**Attachment D:**  
**Hyak FPUD Amended Compliance Review Matrix -**  
**April 24, 2018**

**Hyak PUD Amended Compliance Review – UPDATED April 24, 2018**

Planned unit development of originally 650 units and then reduced to 622 units, now 392 units mixed between multi (344) and single family (48). Project received preliminary approval on January 18, 1994. Resolution No. 94-12.

**DEVELOPMENT, STORMWATER AND
 PARKING PLAN - PARCEL D**

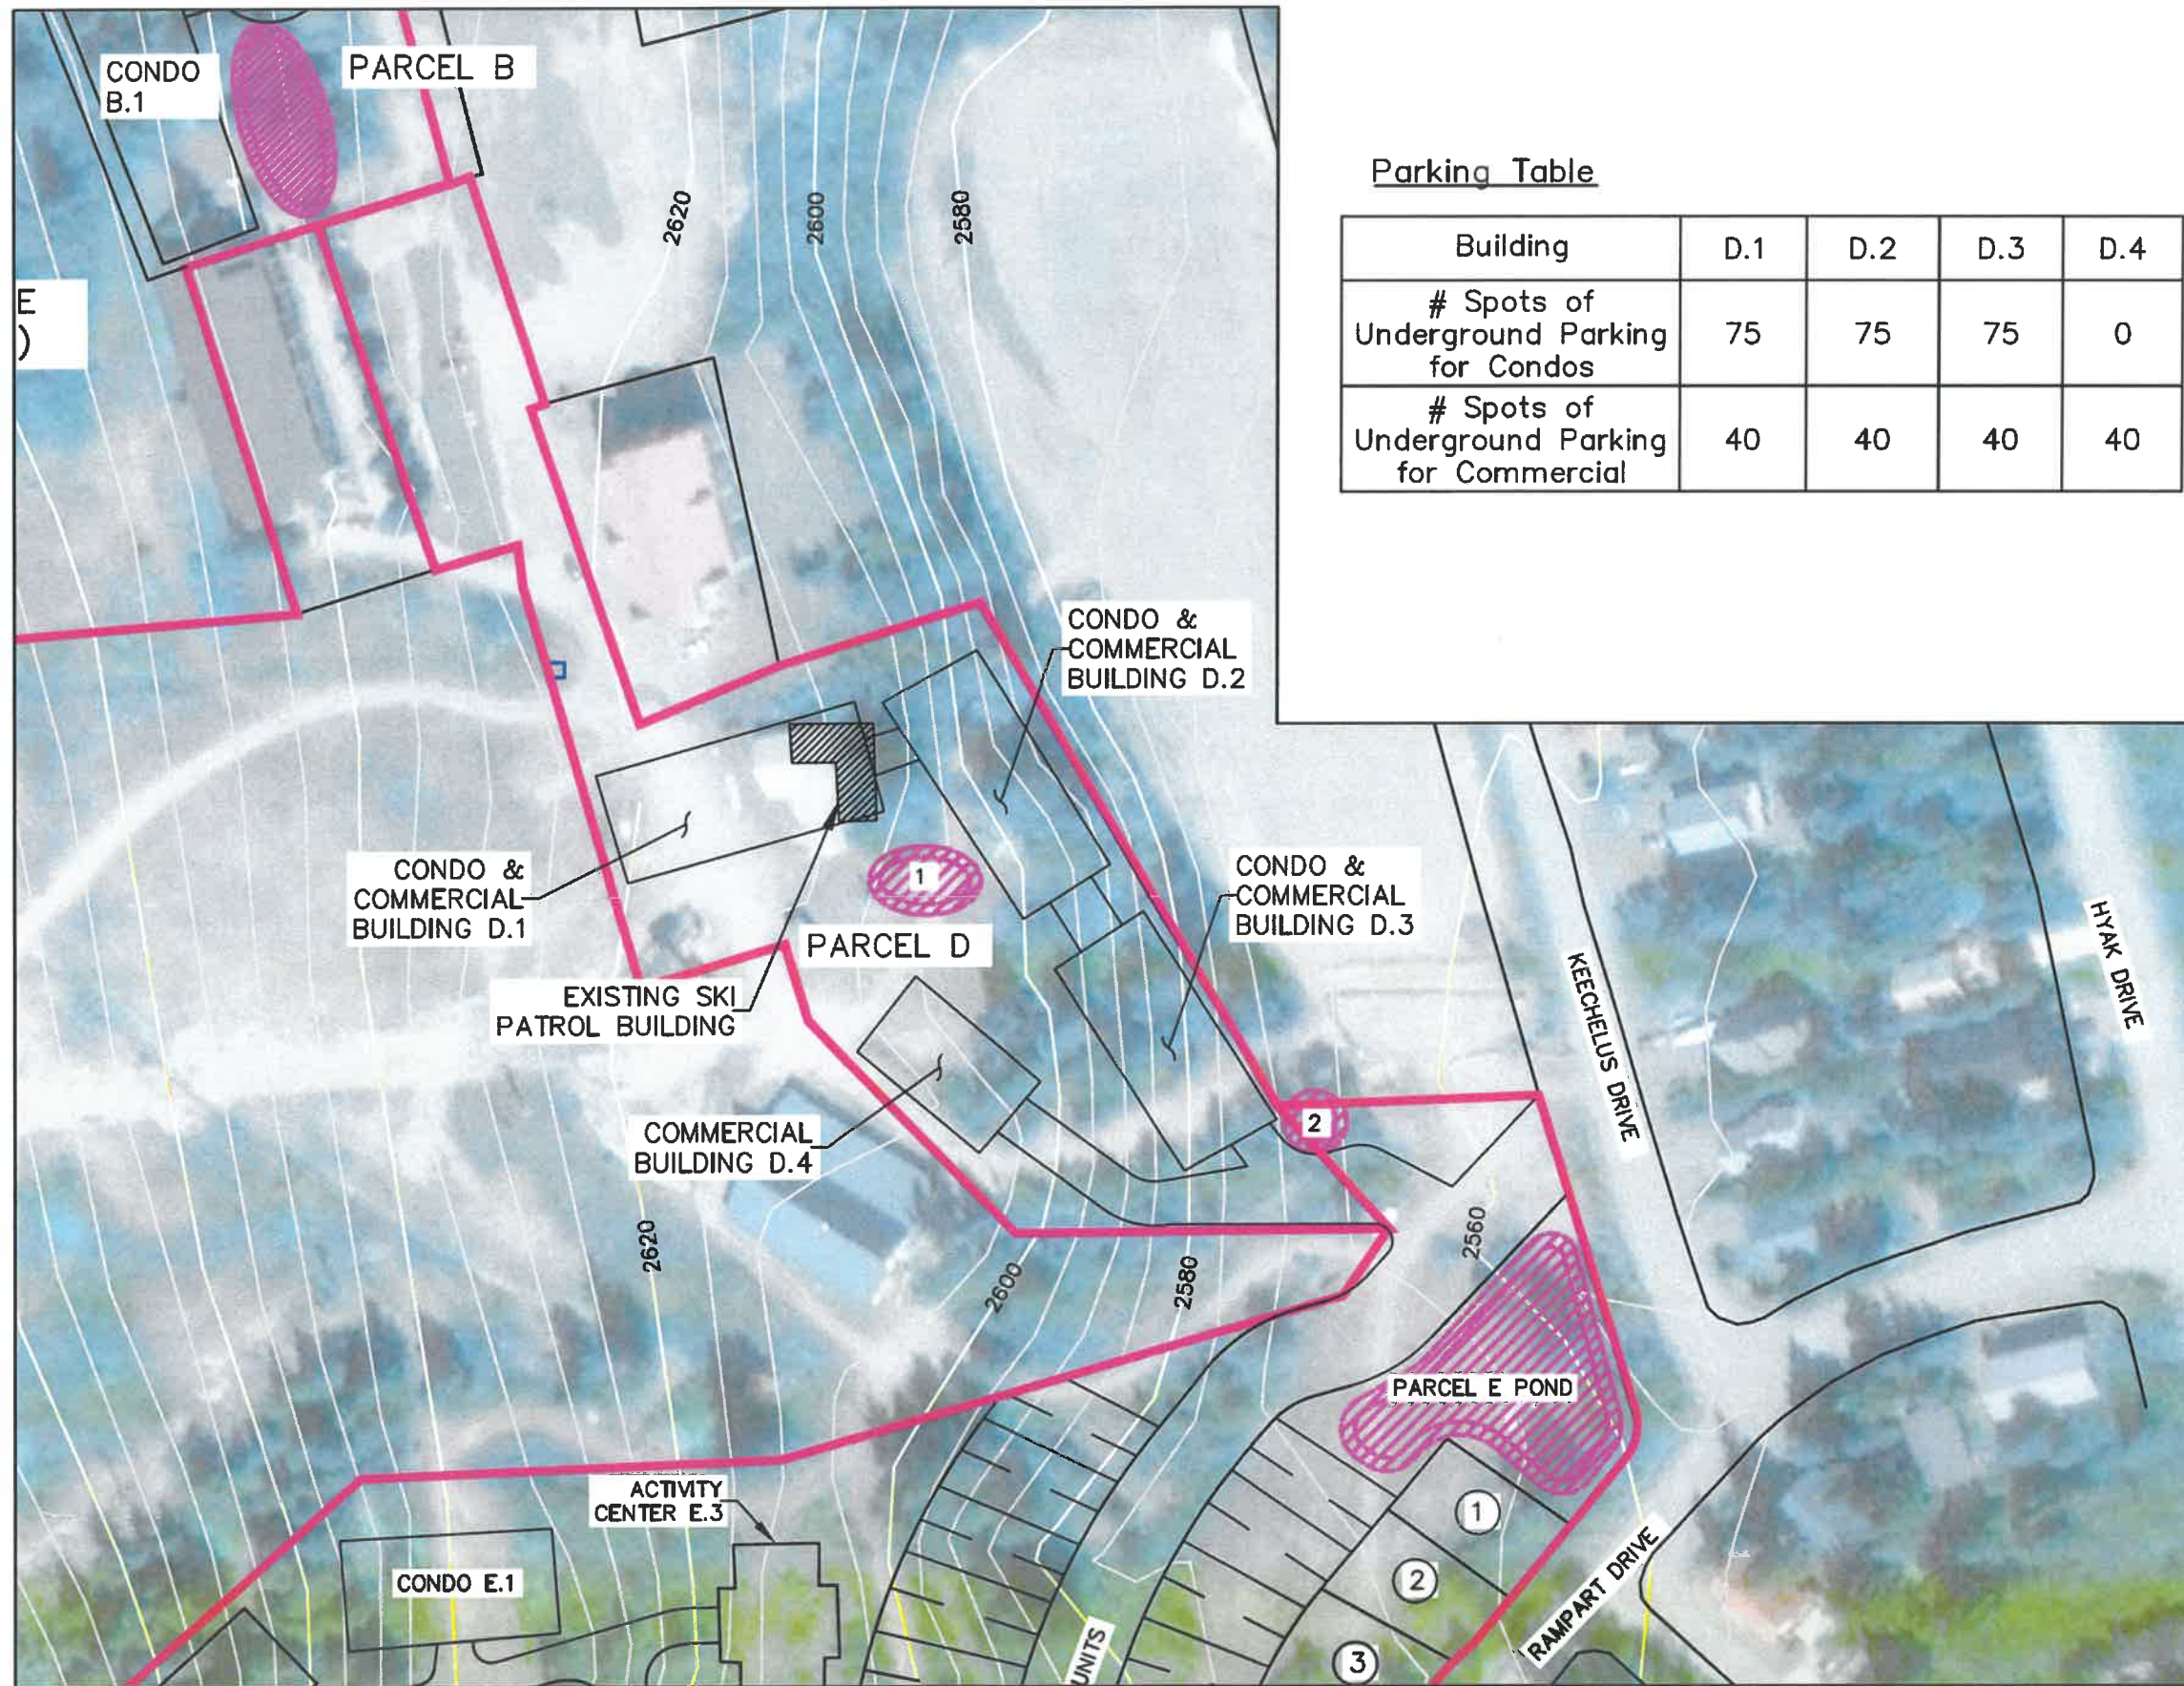
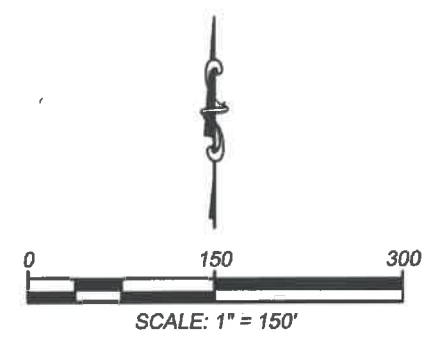
B.13	Along with the final development plan, a definitive parking plan shall be submitted providing a parking density of 1.5 parking spaces per multi-family unit. Parking space or stall dimensions shall be approved by the County Engineer.	The application provides for one (1) parking space per condo unit, needs to be 1.5 per unit at minimum per approval condition and Public Works memo. Applicant shall address. New parking plan and explanation submitted on February 15, 2018. <b>(Index 23 &amp; 28 of Master File)</b>	<b>Satisfied</b>

Generalized Lot Drawing
Specific Definitions On Attached Document

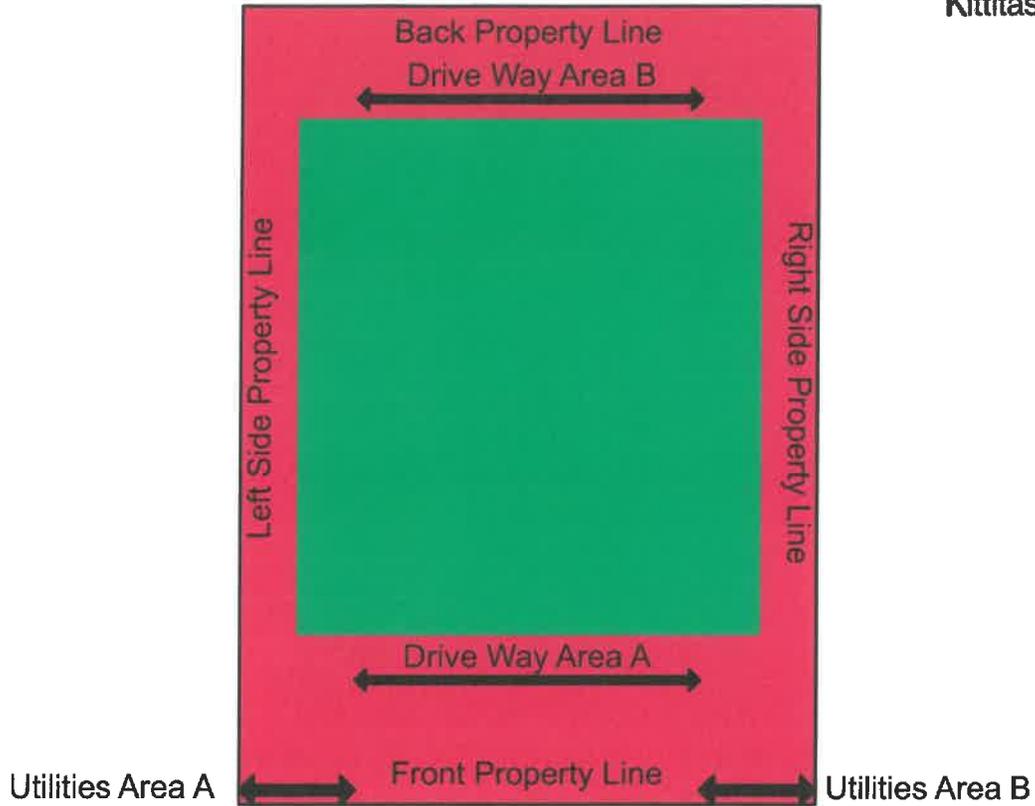
B.4	The applicant shall prepare and submit a final site grading and contour map for the entire property, indicating all erosion and sedimentation control features. The final grading plan shall be submitted prior to the final plan approval.	Pursuant to Public Works memo and project background and narrative, this shall be addressed prior to final plat. A contour map is necessary prior to FDP approval. Contour map of the property was submitted on February 15, 2018. <b>(Index 2, 20, 23 and 25 of Master File)</b>	<b>Satisfied</b>
B.5	All structures on all roadways shall have a minimum front yard setback of 25 feet, side yard setback of 10 feet, and a rear yard setback of 15 feet. The footprints for the buildings shall be shown on the final development plan and shall be binding.	Applicant shall update narrative and amend lot drawing to identify conditioned setbacks. Updated lot drawing showing setbacks was submitted on February 15, 2018. <b>(Index 22 &amp; 23 of Master File)</b>	<b>Satisfied</b>
